Tia Mills
Housing and Key Sites Assessment
Department of Planning, Housing and Infrastructure
4 Parramatta Square, 12 Darcy Street
PARRAMATTA NSW 2124

16 March 2026

**Subject: Environmental Impact Statement – Opal Healthcare Bayview (SSD- 77240466)
(Northern Beaches)**

CPHR comments on Environmental Impact Statement – Opal Healthcare Bayview (SSD- 77240466) (Northern Beaches)

Figure 17. Impacts summary and offset requirements.

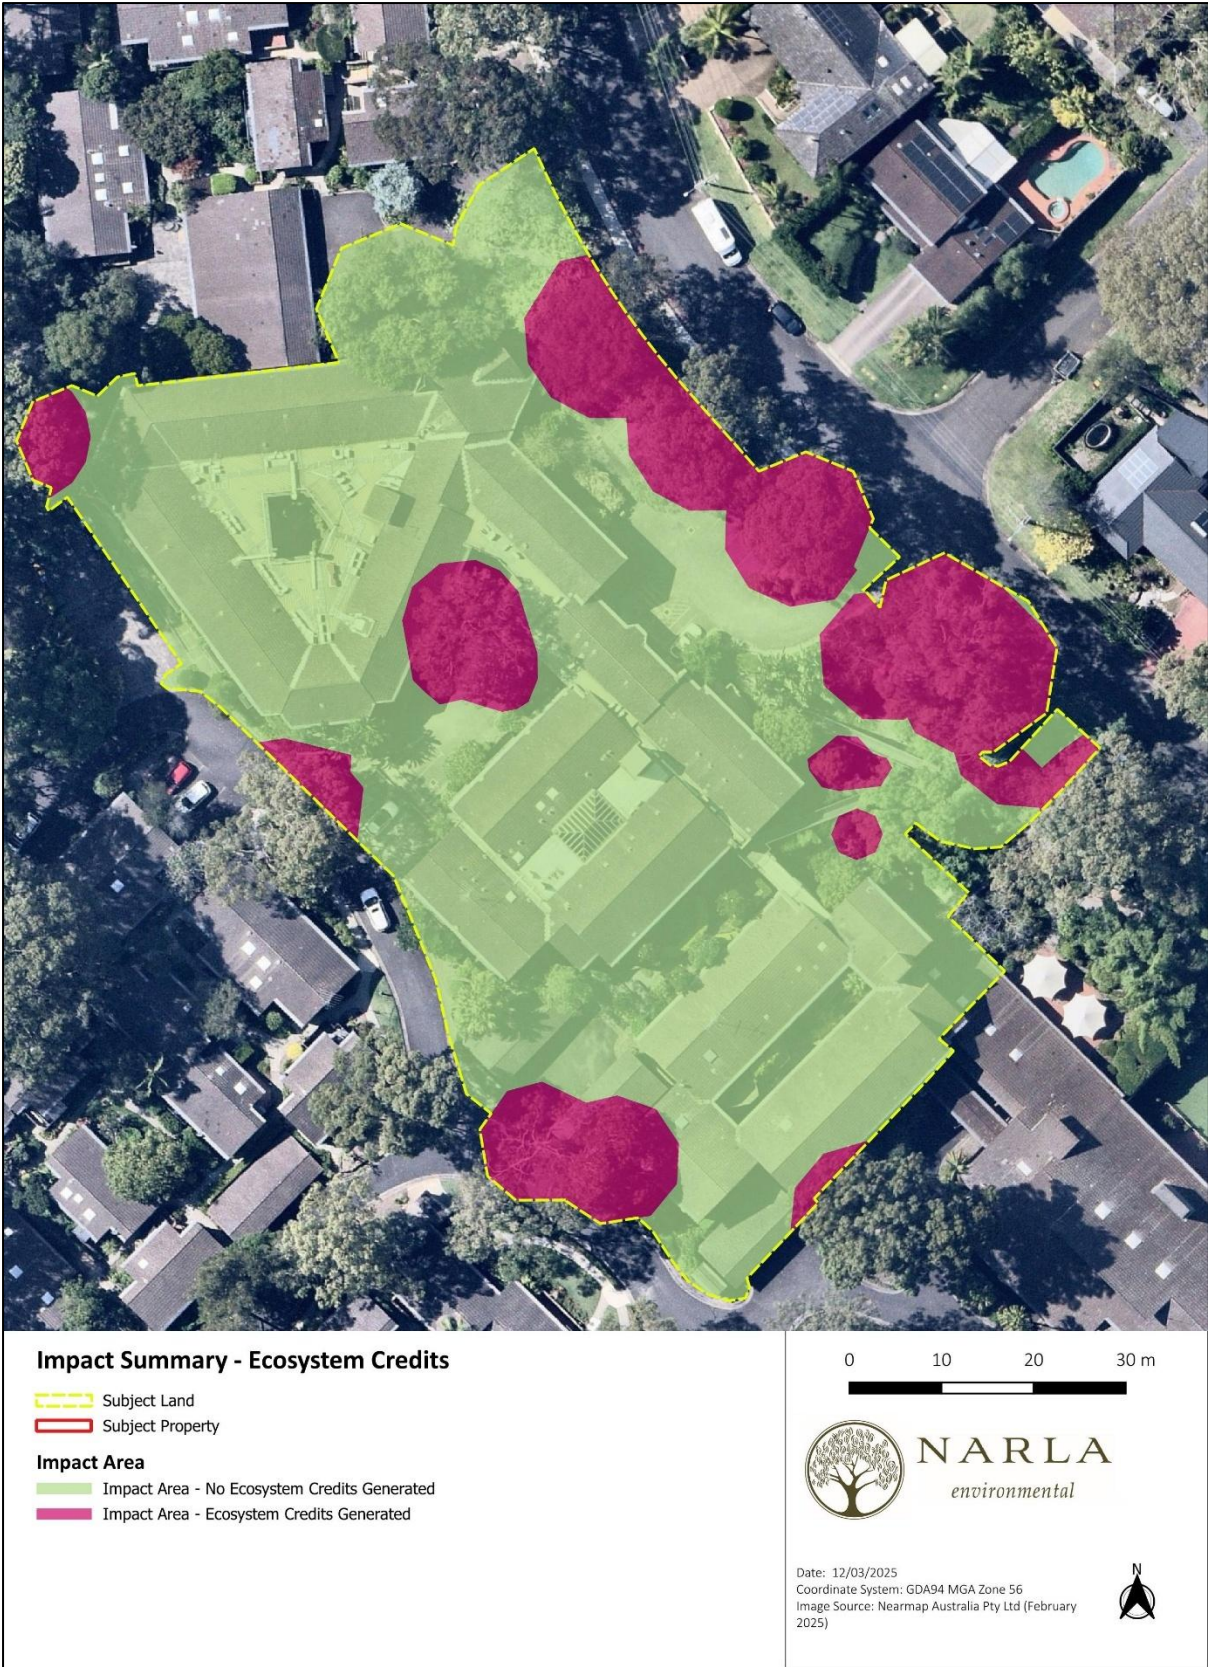
3.	Clarify the extent of the impact area	<p>The full extent of the development impact footprint requires clarification. Figure 17 of the BDAR shows partial impacts to trees along the southwestern and southeastern boundary. However, aside from Tree 79, the stems of the native trees associated with PCT 3234 occur across the existing internal road and do not appear to be proposed for removal.</p> <p>Neither the AIA or BDAR indicate if these trees will be subject to pruning and ongoing maintenance.</p> <p>Recommended action:</p> <ul style="list-style-type: none"> • Update the AIA or BDAR to clarify if these native trees will be subject to impacts. If these trees are proposed for removal, amend the BDAR mapping and BAM-C accordingly.
	<i>Extent and Timing</i>	Pre-determination
